**Consultation Response from KC,
Lead Local Flood Authority**

2023/91870 Rough Nook Farm, 112, Mill Moor Road, Meltham, Holmfirth, HD9 5LW

Discharge conditions 2 and 3 (materials), 4 (retaining walls), 5 (drainage), 6 (watercourses), 8 (temporary surface water drainage), 9 (outfall details), 10 (adoptable road details), 12-16 P(hase 1 & 2 Ground Investigation Reports), 17 (EV charging points), 18 (construction traffic), 20 (EDS) on previous permission 2018/94006 for variation condition 2 (plans/specification) on previous permission 2017/93015 for erection of 19 dwellings (C3) with associated parking with vehicular access

Date Responded: 8th November 2024

Title: Section 104 Drainage Layout and Schedules

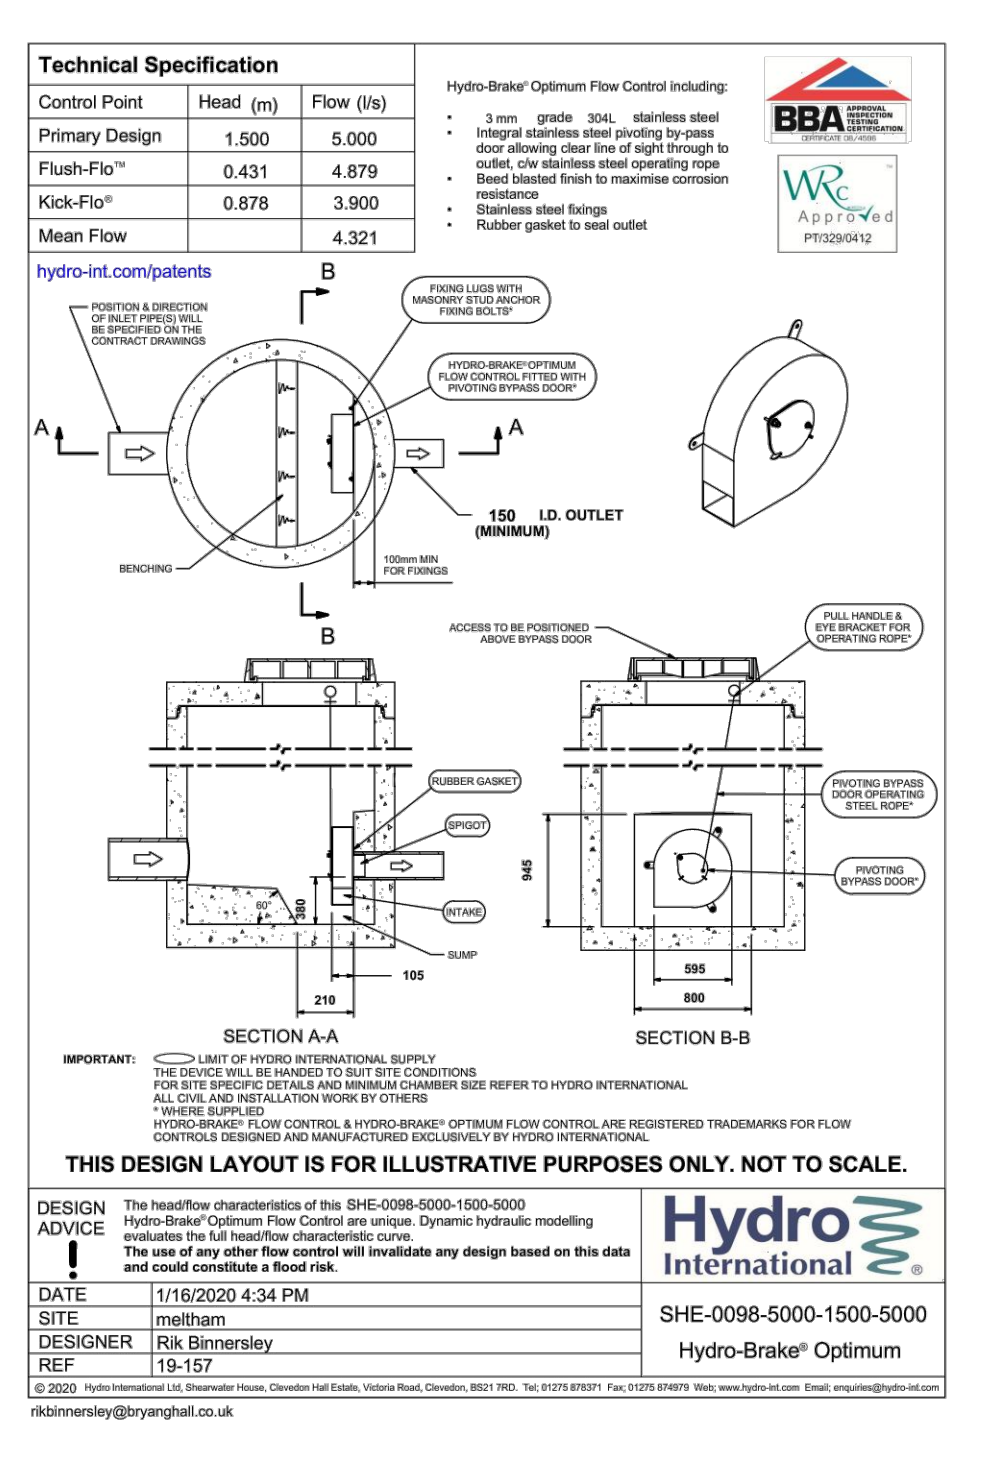
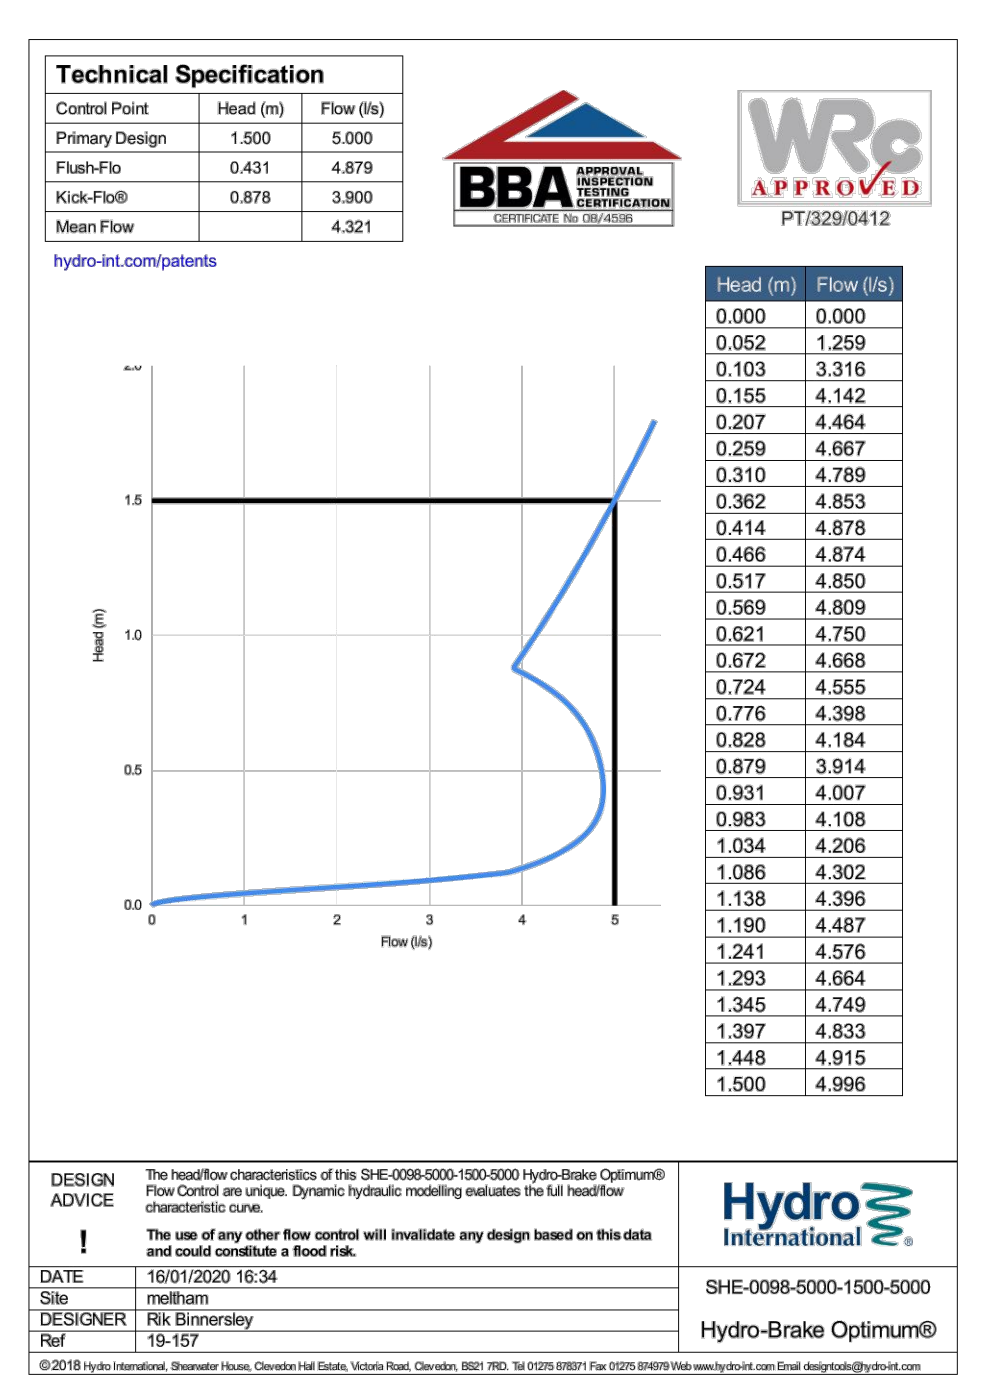
Updated section 104 drawings have been submitted appearing to indicate a acceptable flood route. However, other drawings have not been updated to reflect this. The applicant should ensure that all drawings showing levels reflect this update including section 38 submissions and long sections.
